POST EPC MEMORANDUM

TO: CABQ Development Facilitation Team (DFT)
FROM: William Steele, Senior Planner
DATE: 03/14/2025
RE: PR-2020-004098, SI-2024-01284 – Site Plan – EPC

SI-2024-01284 – Site Plan – EPC

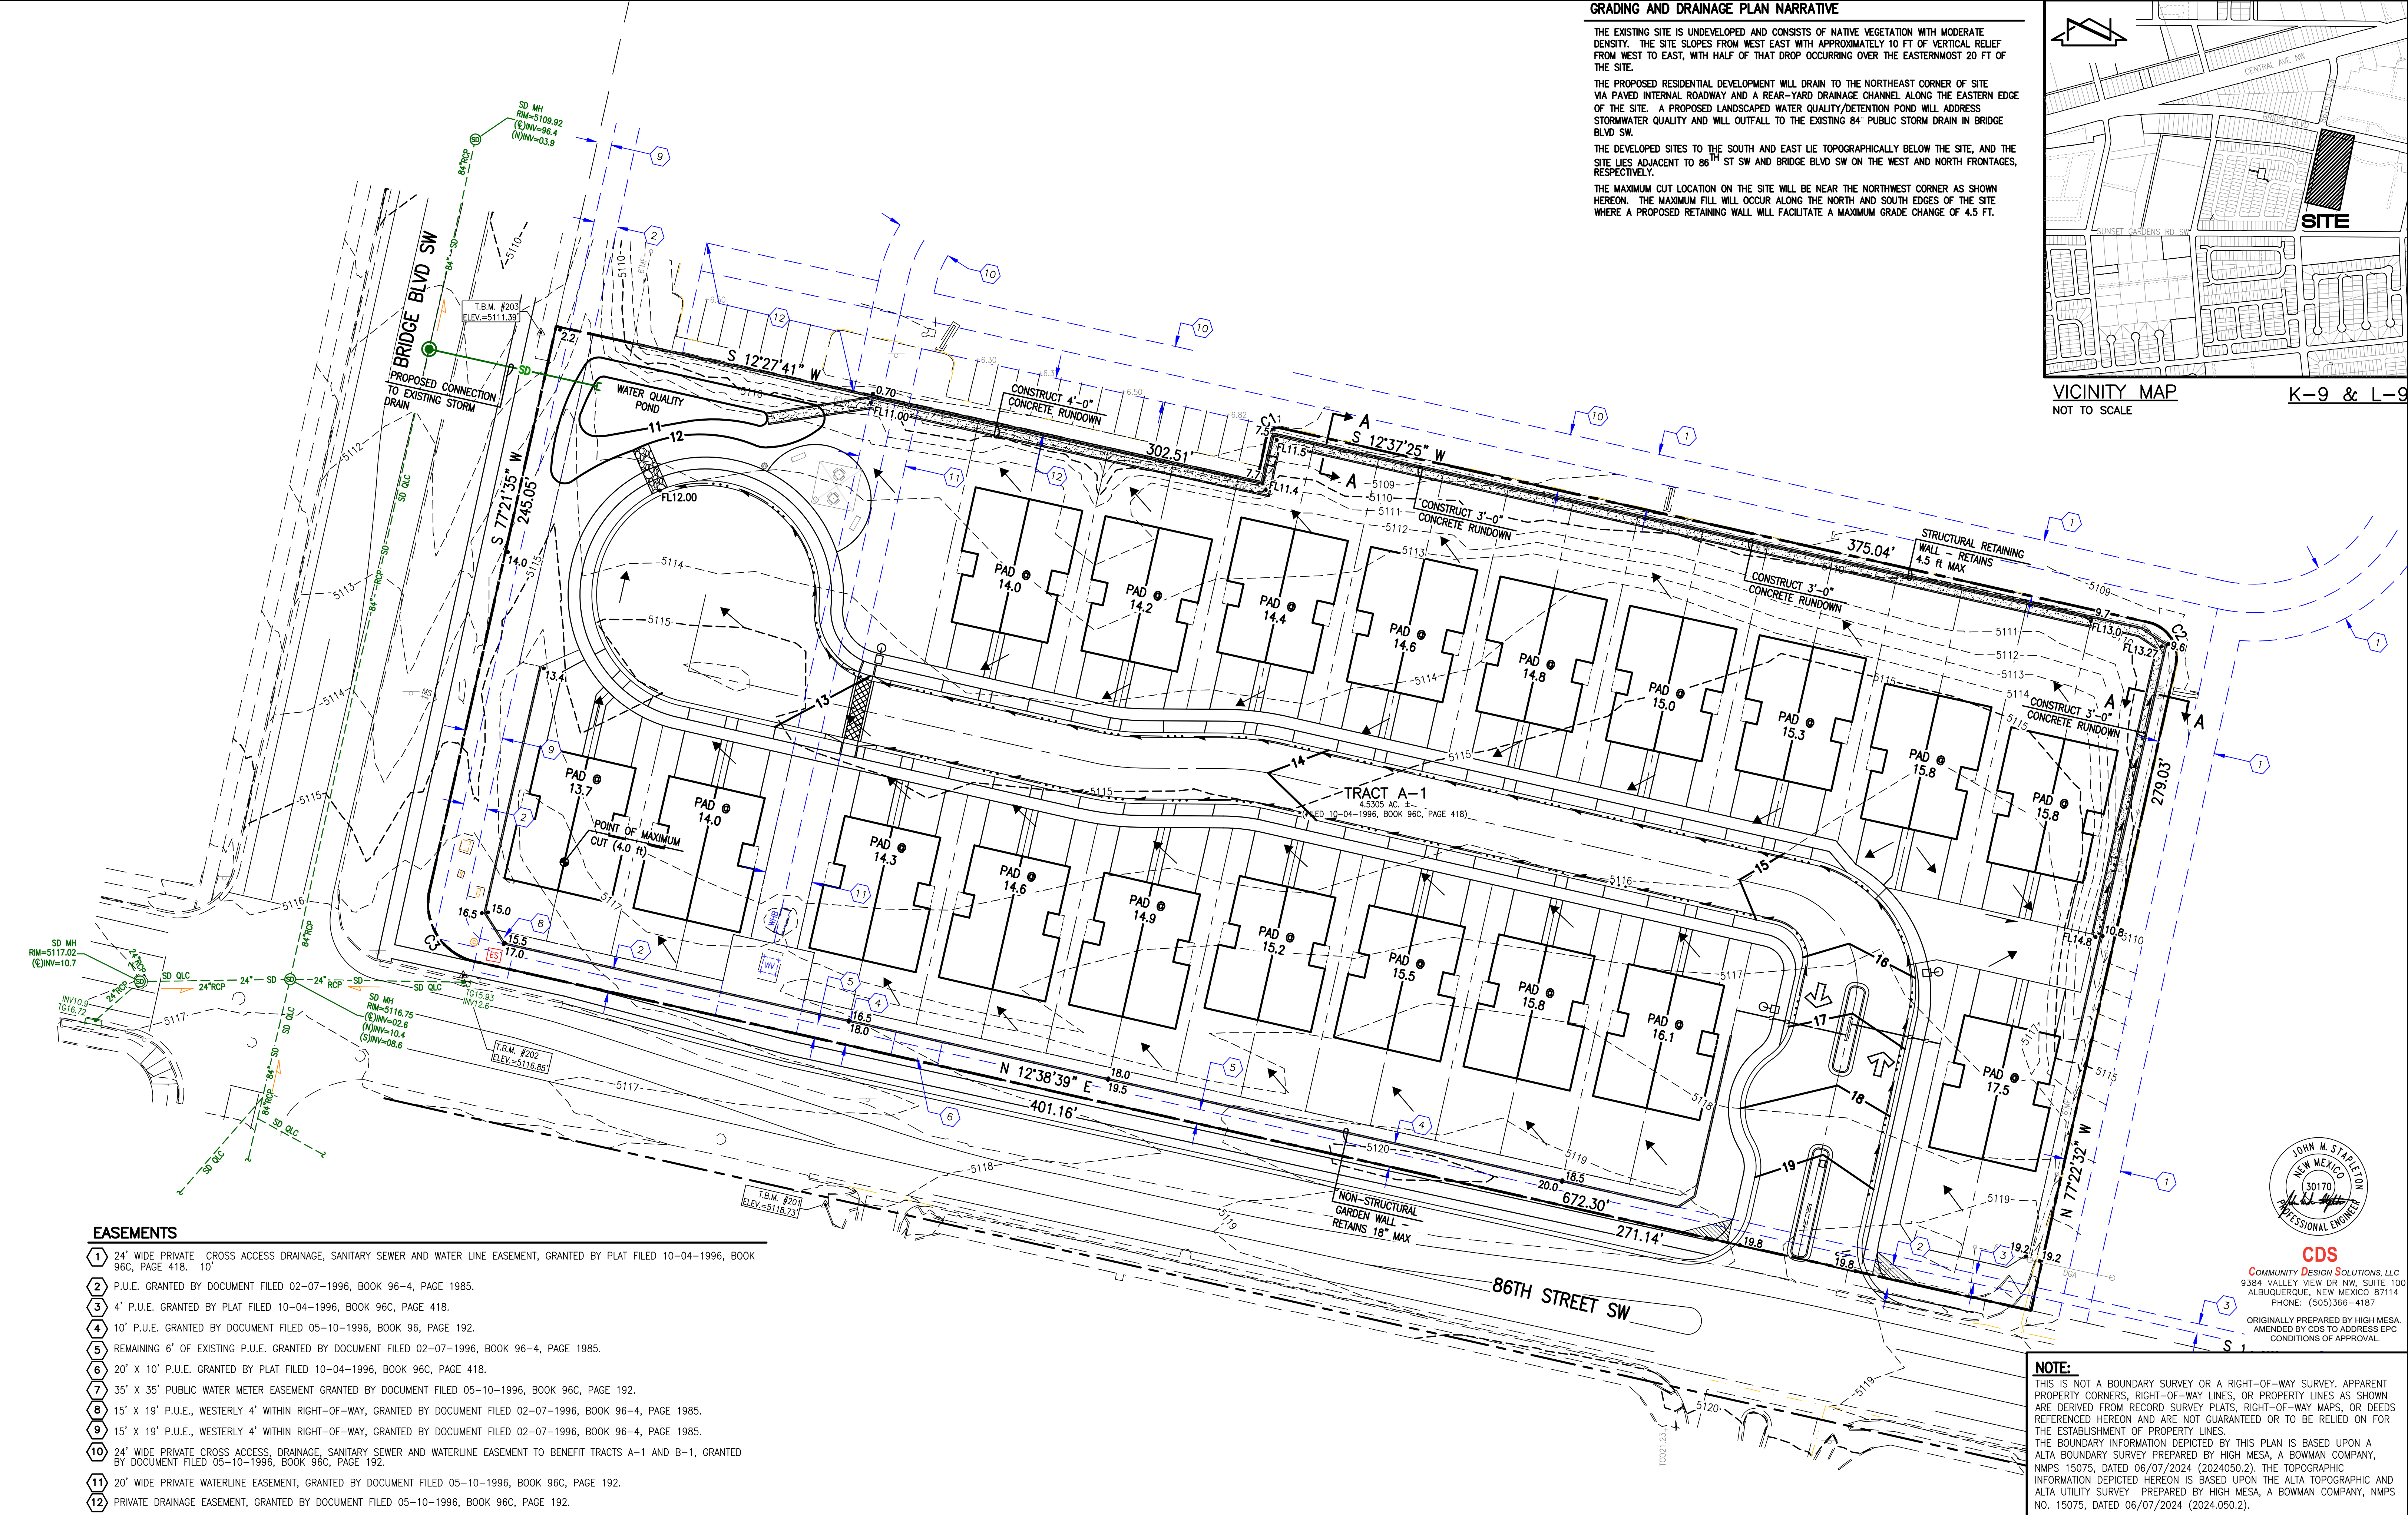
9. Condition 9 (A-D) has been met for the Grading and Drainage Plan (CG101):

- A. The GRADING PLAN has been renamed GRADING AND DRAINAGE PLAN.
- B. The GRADING AND DRAINAGE PLAN NARRATIVE has been revised to state “development will drain to the northeast corner of the site.”
- C. Detail Section A-A was removed from this sheet.
- D. The NOT FOR CONSTRUCTION stamp was removed.

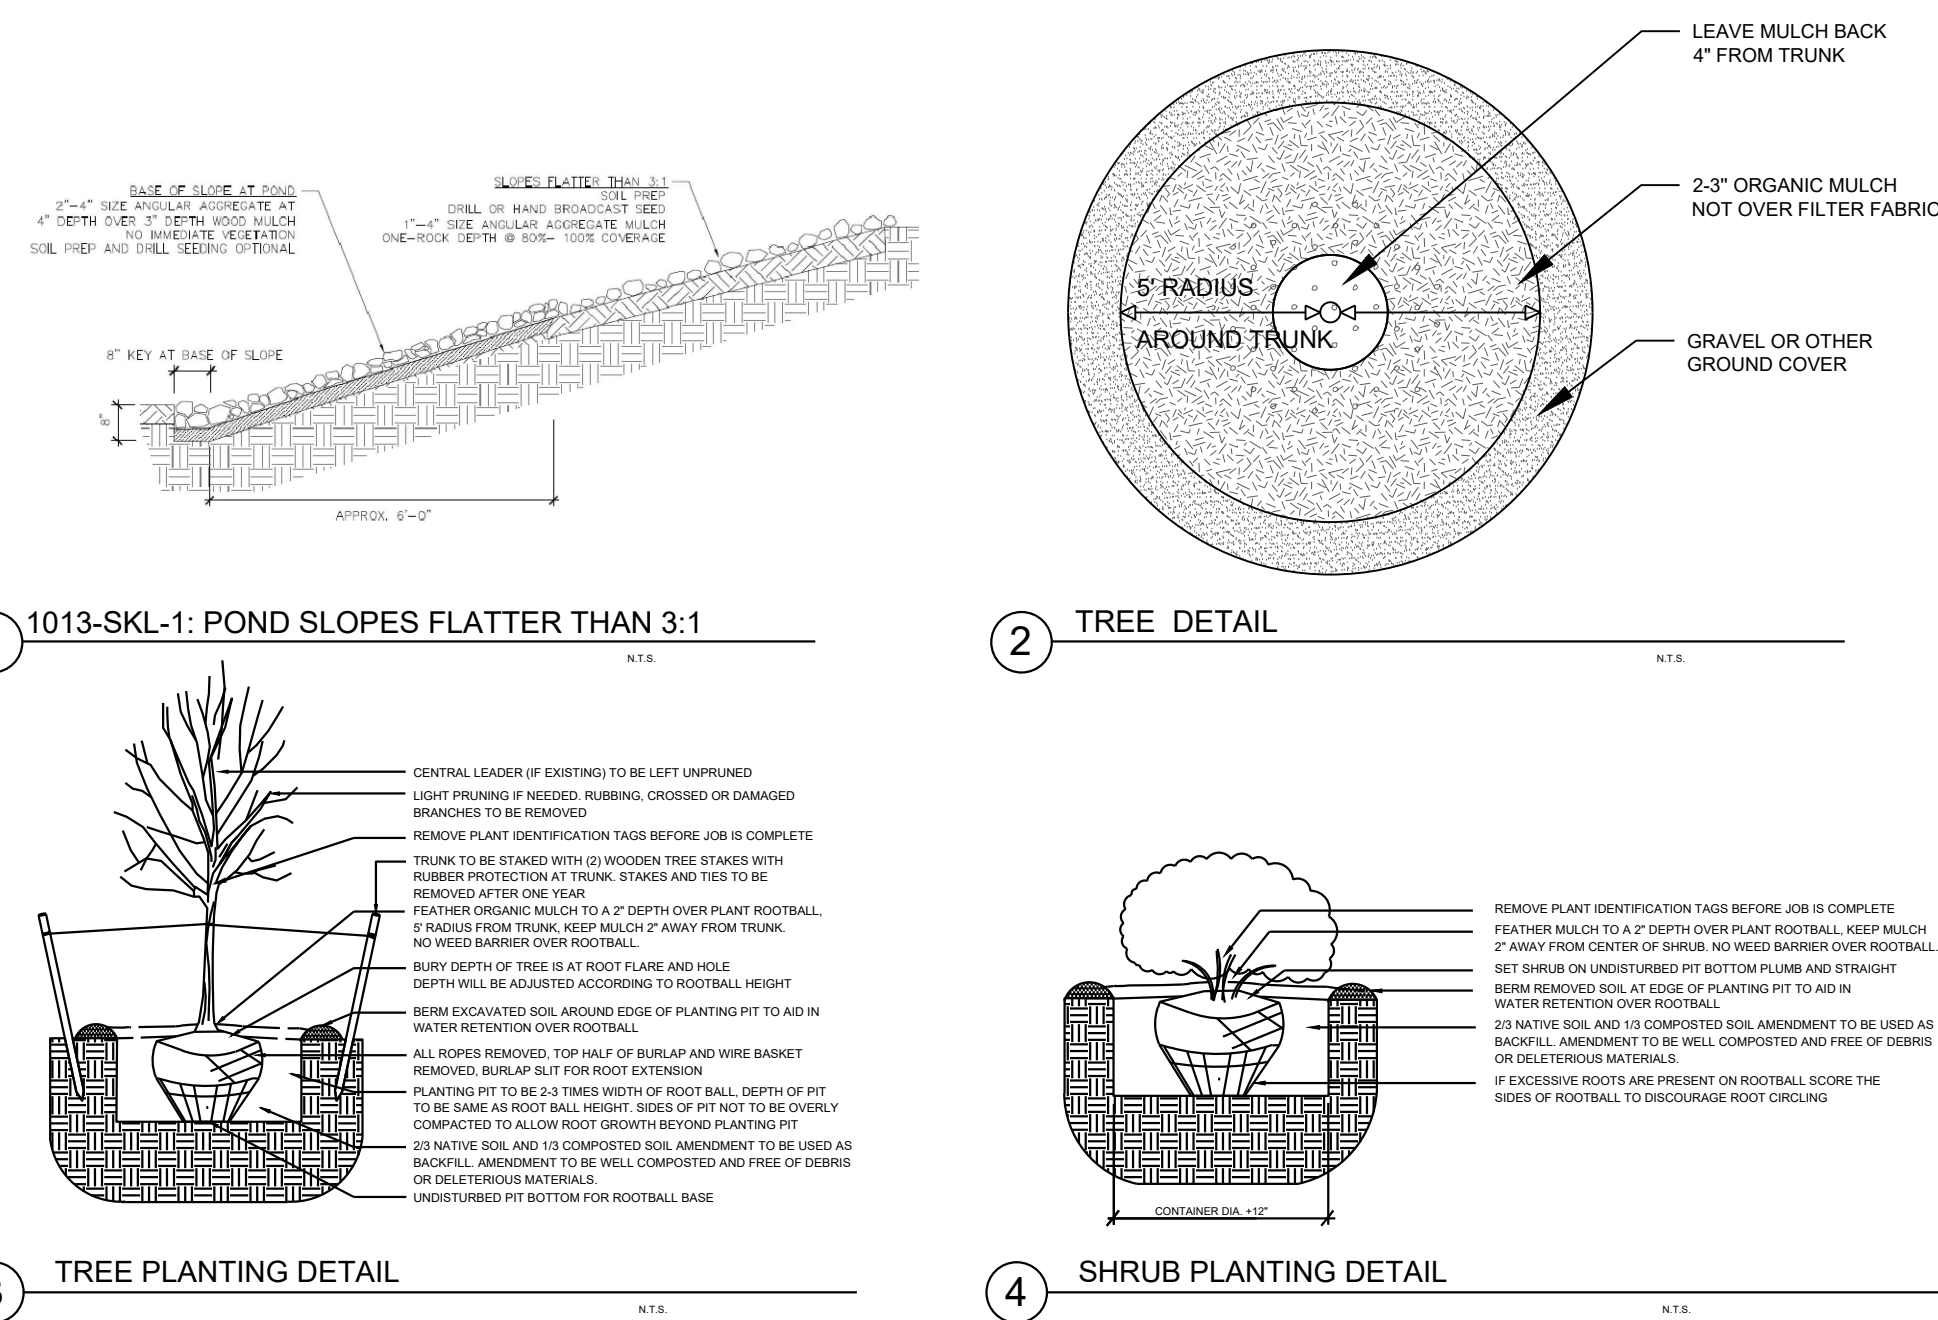
8. Condition 8 has been met for the Landscape Plan (LP-01). The line weight of the building footprints and sidewalks has been increased and are clearly visible.

12. Condition 12 (A-C) from Parks and Recreation - Urban Forestry has been met on Landscape Plan LP-01:

- A. Street trees are shown every 25' on-center along Bridge Blvd. SW on pursuant to Street Tree Ordinance 6-6-2-4. (Reference to this condition was added to the "Table of Applicable Standards" on the Site Plan sheet for Landscaping, Buffering and Screening.)

- B. The applicant has added a note to the Landscape Plan regarding trees mulch: "10' Diameter wood mulch tree ring with no filter fabric." This is in addition to the existing General Note #8 that references IDO 14-16-5-6(C)(5)(e), organic mulch shall be required within a 5-foot radius around the tree trunk, but not directly against the trunk. In these areas, weed barrier fabric is prohibited. (Reference to this condition was added to the "Table of Applicable Standards" on the Site Plan sheet for Landscaping, Buffering and Screening.)

- C. Landscape Detail #1 is now Tree Detail #2 and notes a 5' radius organic mulch is required at base of street trees and to leave mulch back 4" from trunk. Included on the detail is a note stating, "2-3" organic mulch not over filter."

13. Condition 13 from Parks and Recreation - Strategic Planning and Design has been met on Landscape Plan LP-01): A new note has been added to the Landscape Plan stating: "Pond to follow Detail 1. COA Spec Section 1013." A new Detail #1 "1013-SKL-1 Pond Slopes Flatter than 3:1" has been added to the landscape plan. (Reference to this condition was added to the "Table of Applicable Standards" on the Site Plan sheet for Landscaping, Buffering and Screening.)
